28th May 2014

**Planning Application South of Burndell Road, Yapton
Planning Reference F/9/14/PL**

TITLE: Proposed Access and Highway
Improvements Plan

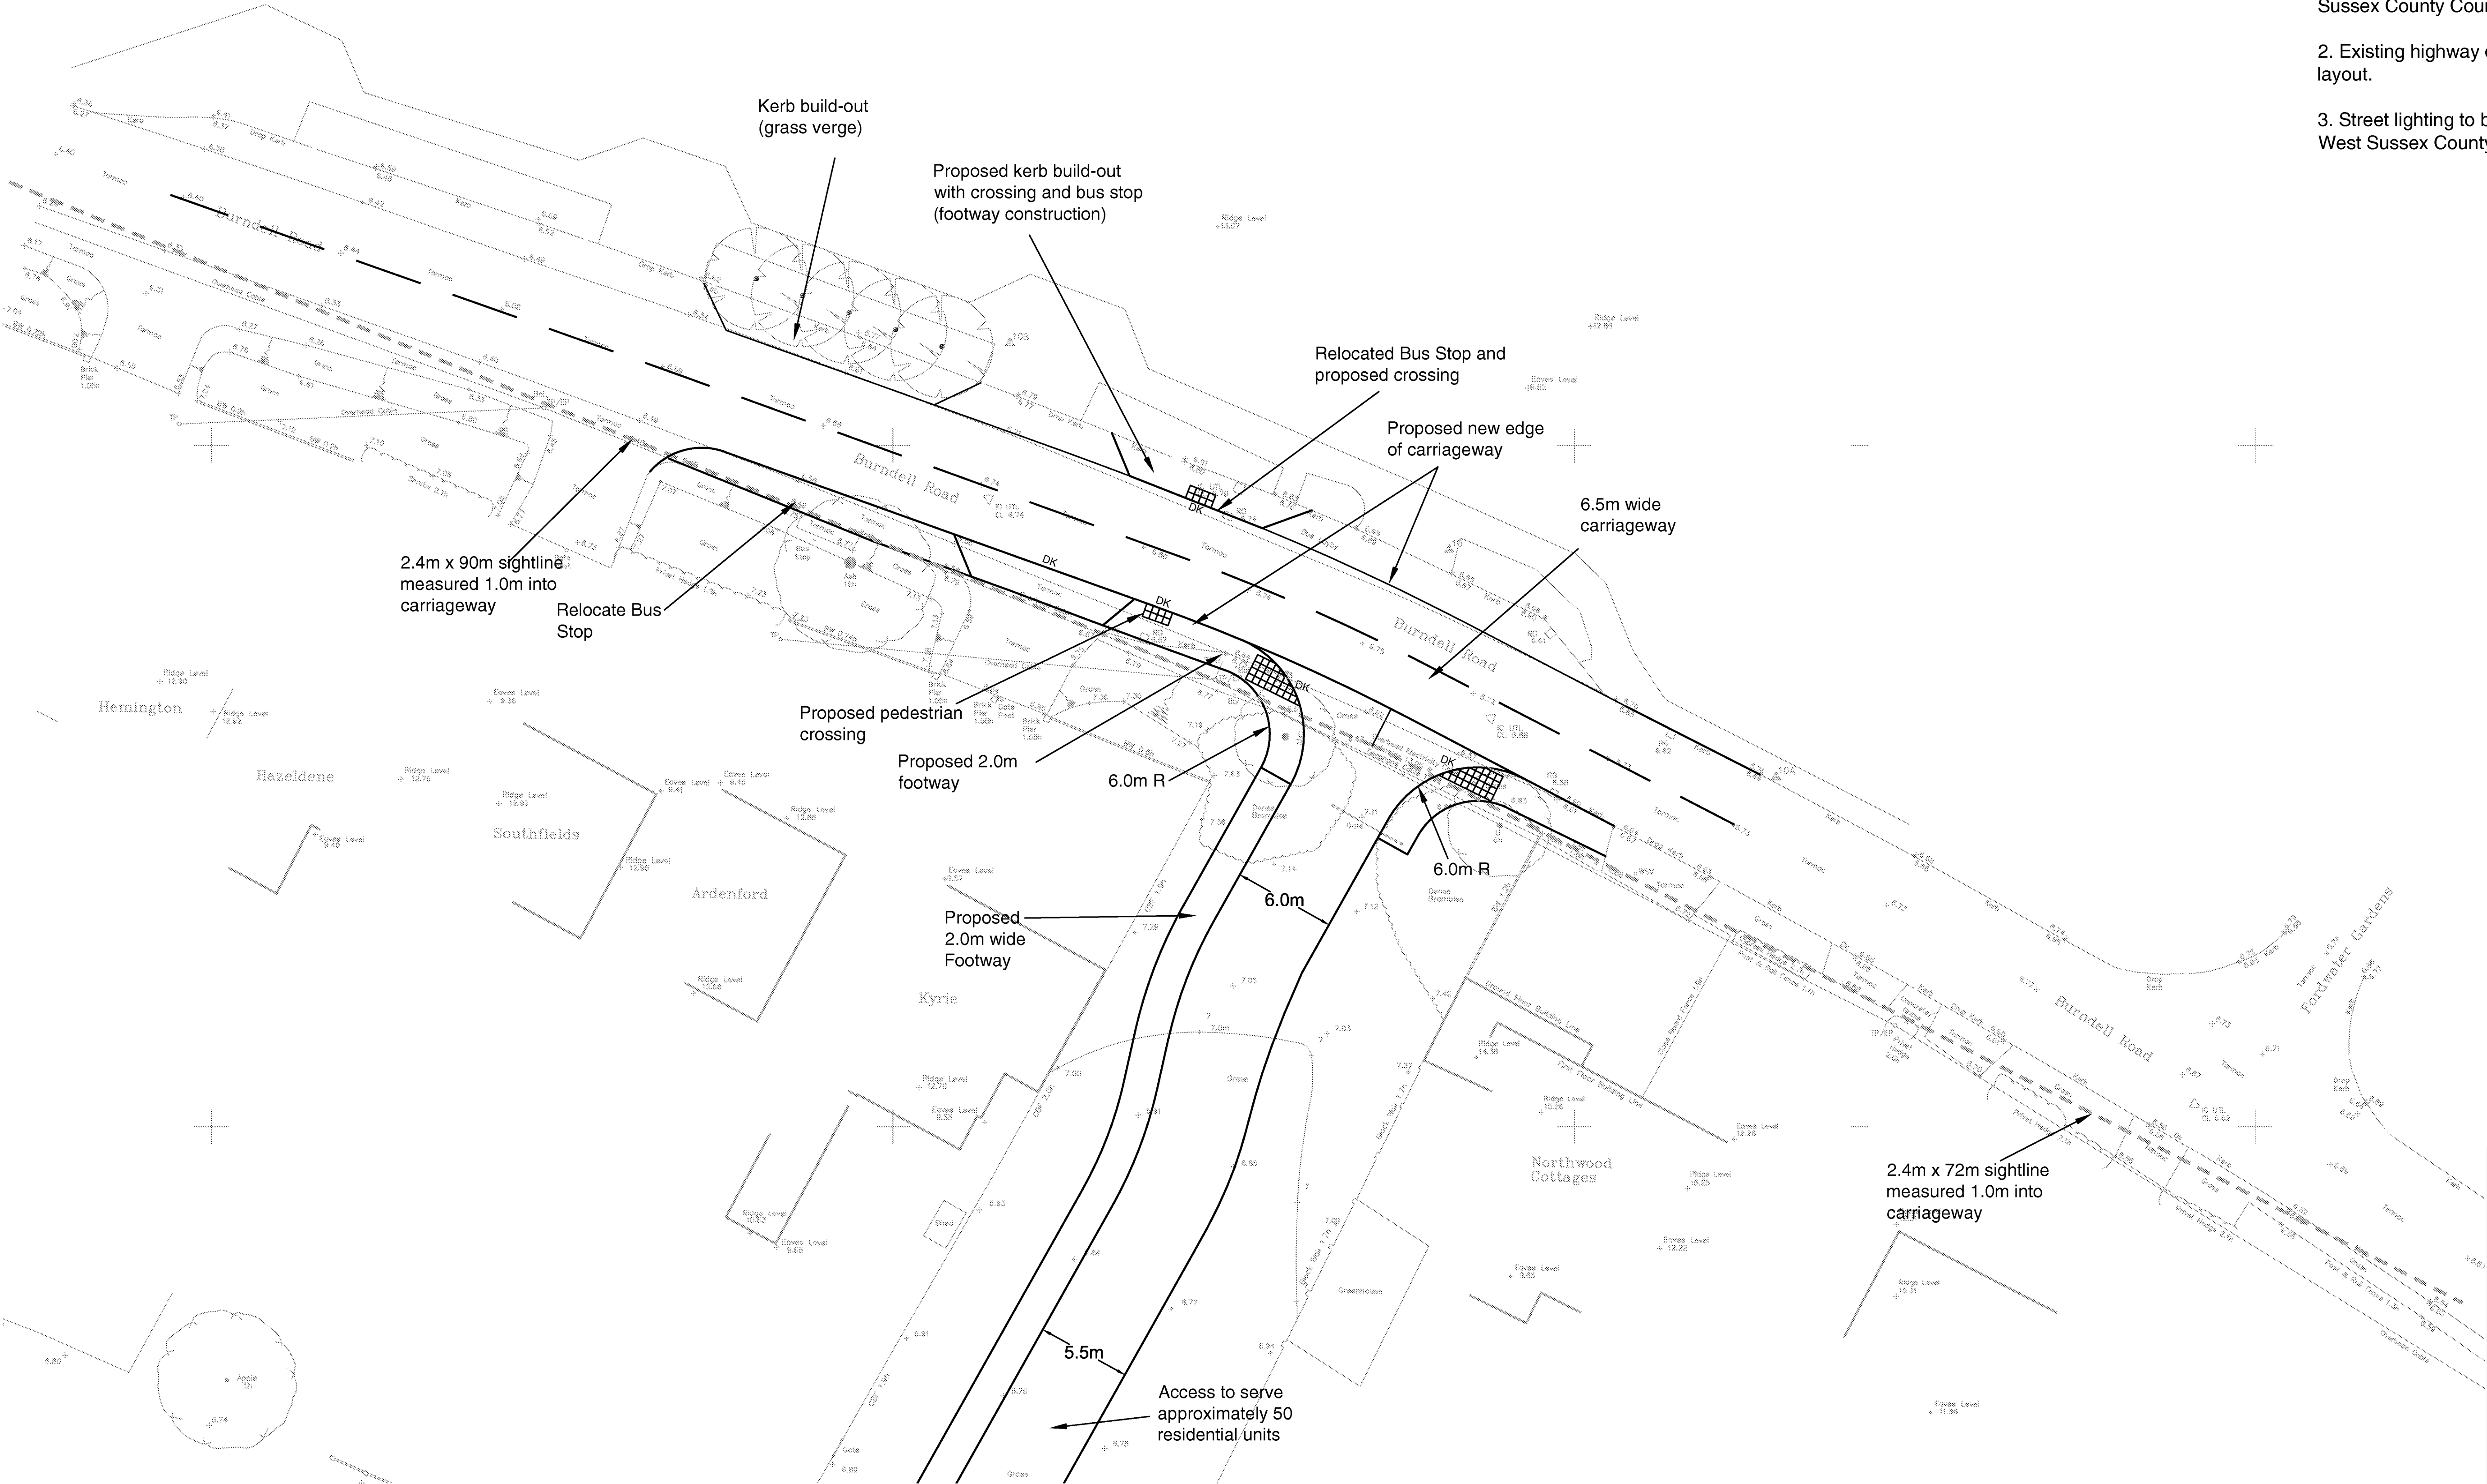
1. The matter of road safety is clearly one to which the developers have failed to give any consideration. The proposed exit road from the development onto Burndell Road creates a blind spot in respect of traffic moving east to west. As a former personal injury lawyer this is an oversight which will result in a number of road traffic accidents; a situation clearly foreseeable. A copy of this letter will be available for motor insurers to consider in the event of the development proceeding.

2. The proposed narrowing of Burndell Road serves no purpose other than to interfere with existing resident access and parking facilities for visitors. Potential for additional road traffic accidents, see above.
